From: Tim Townsend 
Sent: 14 February 2019 14:44
To: Simon Davis <Simon.Davis@arun.gov.uk>
Subject: RE: Y/102/18/DOC (Condition 13 Construction Management Plan)

From a WSCC Highways point of view, I am satisfied that the information provided in your email below of 7th February 2019 (and subject to the previously discussed revised operation and location of the gates adjacent to Burndell Road being included too – i.e. 5m set-back of the site hoarding/gates from the edge of the carriageway of Burndell Road; gates being opened in advance of personnel and deliveries arriving and use of banksmen, when required) now satisfies the highways elements of the CMP.

Construction Traffic Plan

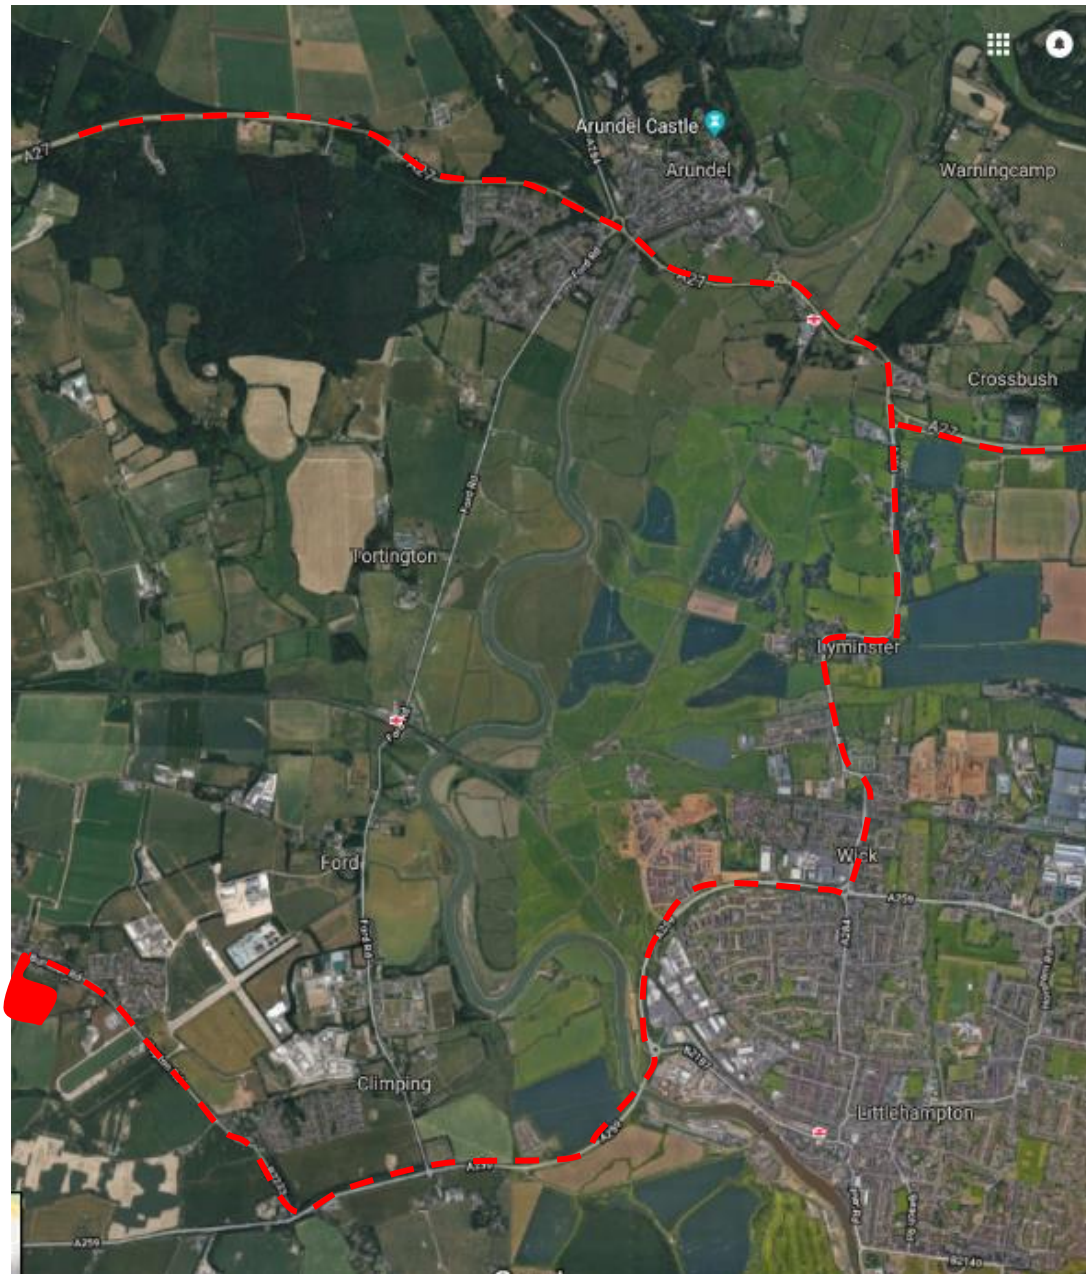
- The heras fencing drawing has now got Rev B noted on it.
- The compound layout (YAPT-SC-001 Rev B) has been updated to show the double stacking of units for materials. Rev B is also noted on the drawing.
- The construction traffic plan has also been updated to Rev B (noted within the title).
- The CMP has had the date amended within it.
